Item No. **Report of the Head of Development Management and Building Control**

Address: MILL ROAD SERVICE STATION MILL ROAD WEST DRAYTON

Development: Installation of an internally illuminated digital display board

LBH Ref Nos: 78043/ADV/2025/23

Title
Existing and Proposed Elevations

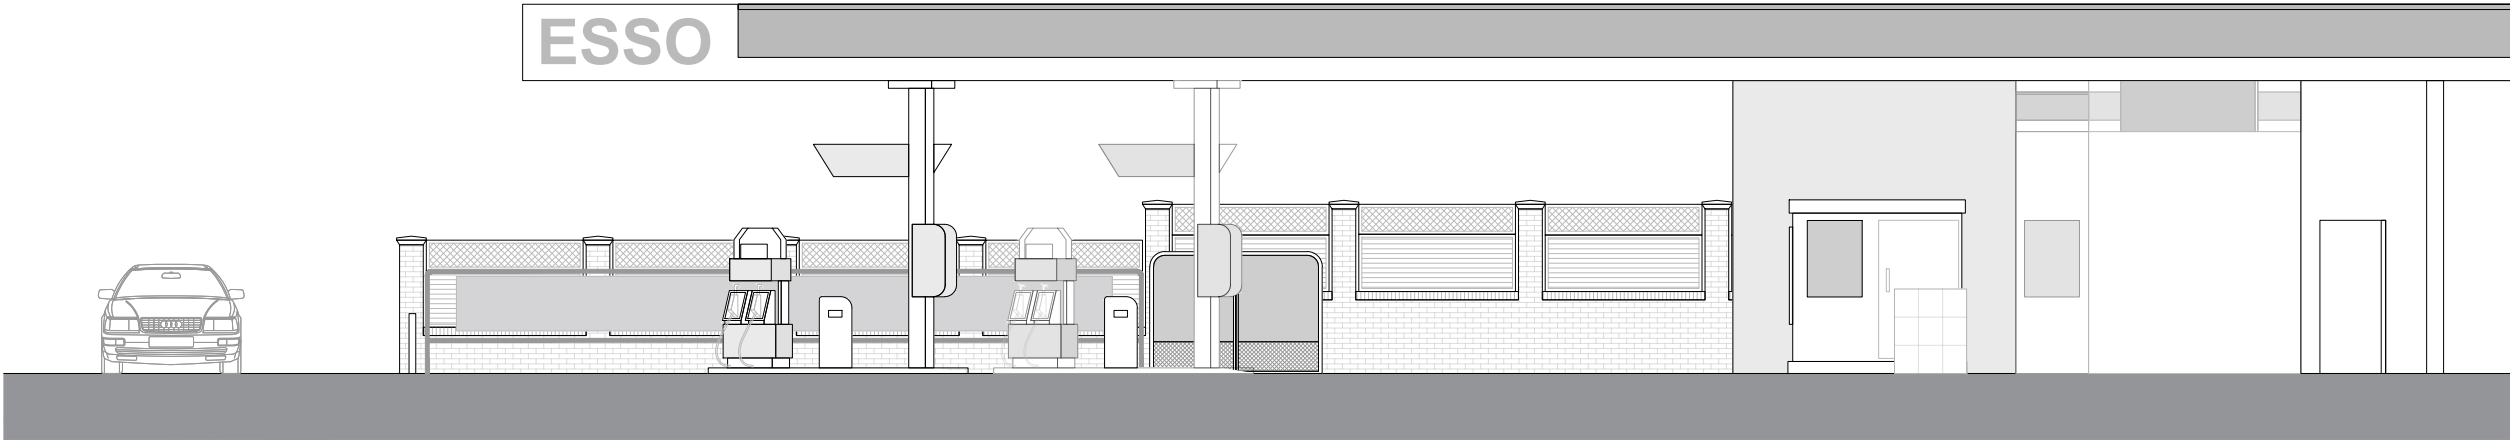
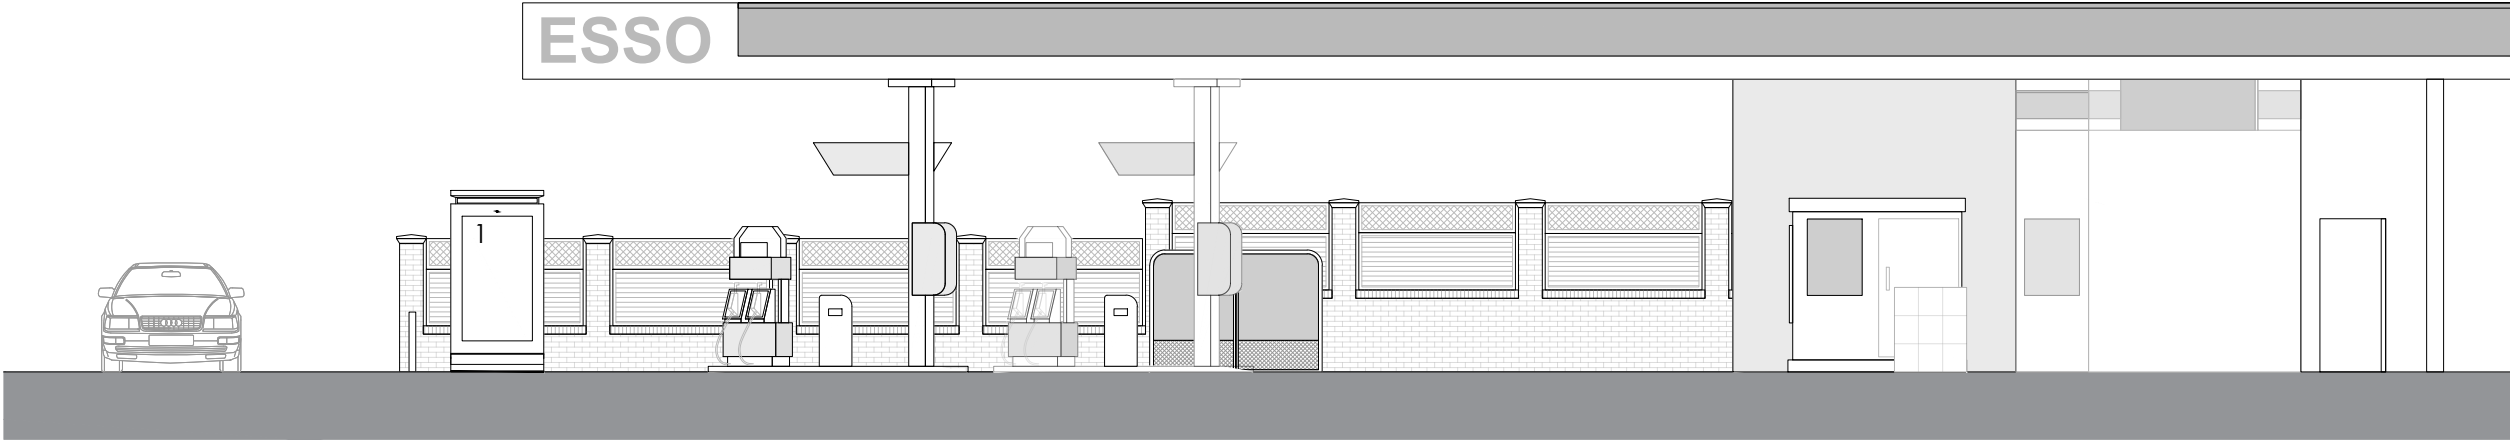
Whilst the display board would be read in the context of the service station, the proposal would have a detrimental impact on visual amenity and character caused by the siting and scale of the display board and its internal illumination. As a result, the proposal would not preserve or enhance the character and appearance of the conservation area. The harm identified to the heritage asset would fall into the category of 'less than substantial harm'.
